Norfolk County Council Response to Qu.19.29 (Socio-Economic)

Your Ref: EN010079  
My Ref: 8/1/18/0088

**Application by:- Norfolk Vanguard Limited for an Order Granting Development Consent for the Norfolk Vanguard Offshore Wind Farm Project  
The ExA's Written Questions and Requests for Information**

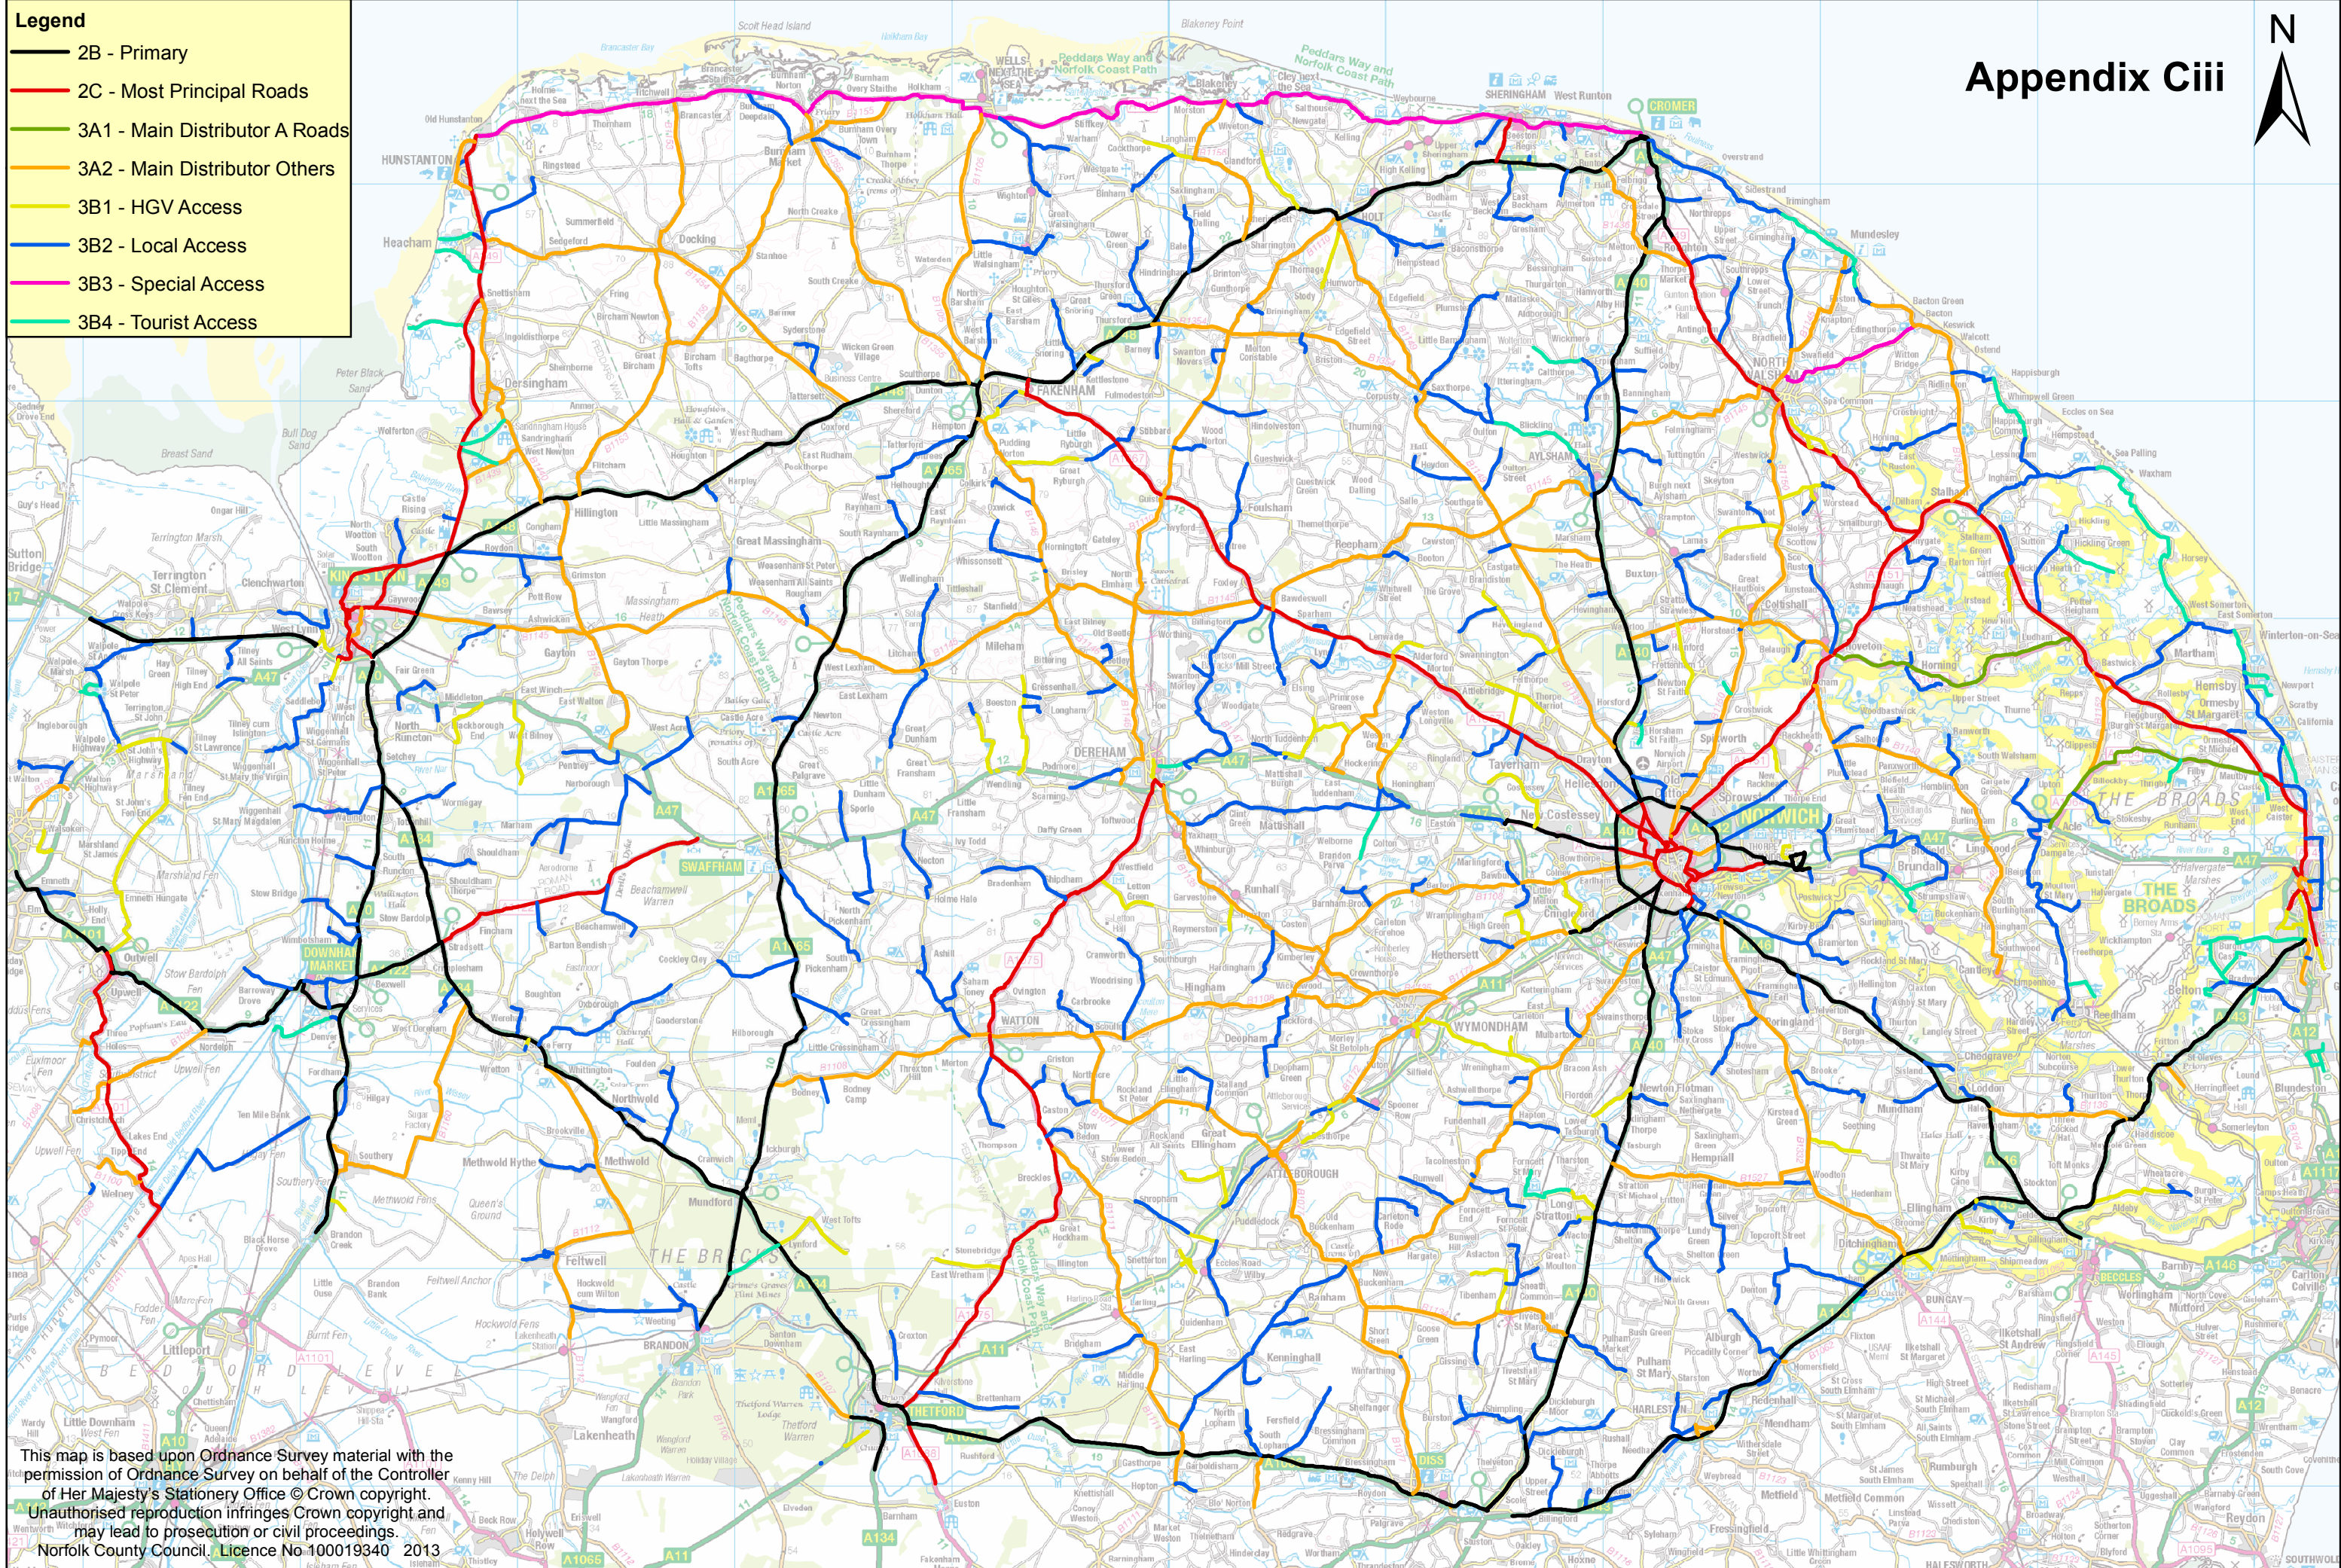
Following the opening of the NDR, the A1067 is now a very heavily trafficked road and is recorded within the County Councils route hierarchy as a principal route which links primary destinations. Given the importance of the route within the hierarchy and the levels of traffic that it now carries, open cut trenches to the A1067 at this point will lead to unacceptable traffic delays. This is particularly the case given the level of traffic mitigation that will be required.
